**Project# 1003094**

12DRB-70329 MINOR - PRELIMINARY/ FINAL PLAT APPROVAL

ISAACSON & ARFMAN PA agent(s) for CASITAS DE COLORES, LLC request(s) the referenced/ above action(s) for all or a portion of **SILVER TOWNHOMES** zoned SU-3, located on the south side of SILVER AVE SW between 2ND ST SW and 3RD ST SW containing approximately 1.5145 acre(s). (K-14)

1925 V-FINAL PLAT.dwg Sep 28, 2012 **SHEET 2 OF 4**

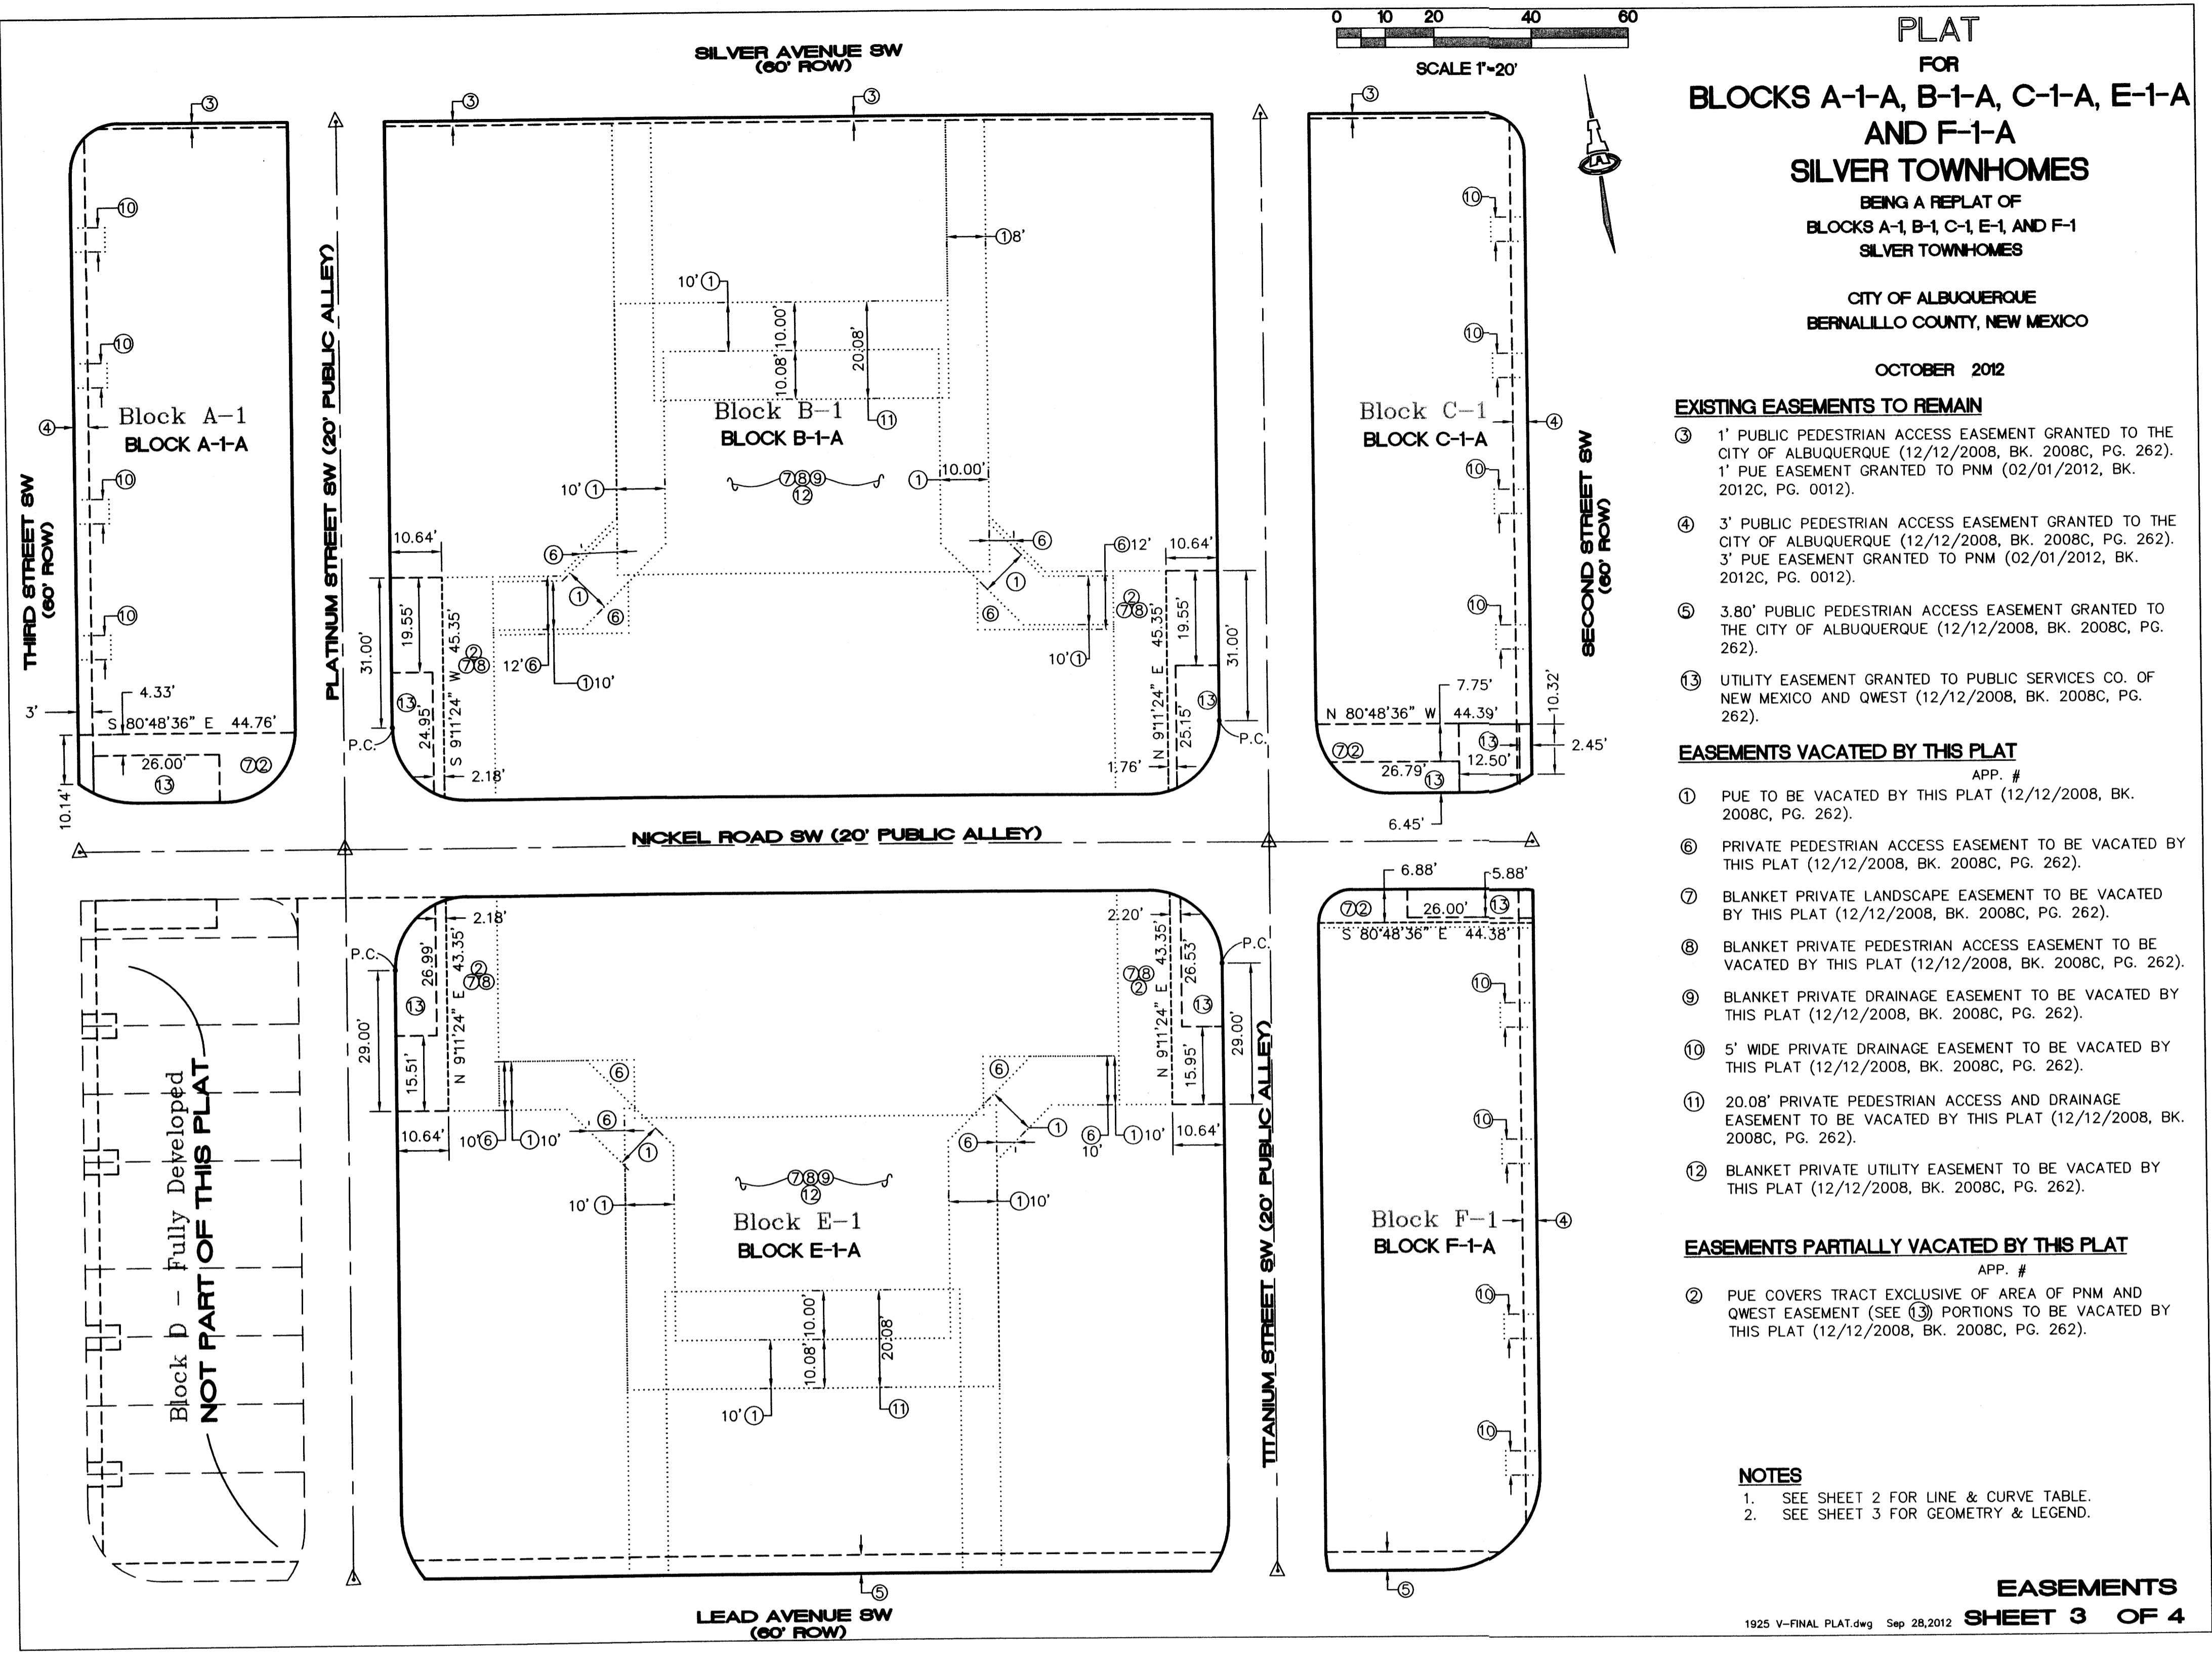
Hydrology has no objection to vacating the pedestrian, landscape and utility easements. The drainage easements on Block D cannot be vacated. They area shown as "X'd" out. The remaining drainage easements can be vacated with the condition that private drainage easements are provide to drain Block C-1-A and A-1-A to the cistern on Block B-1-A and to drain Black F-1-A to the cistern on Black E-1-A. Easements area required to provide ponding of the first 0.5" of rain per agreement 8-9-12.
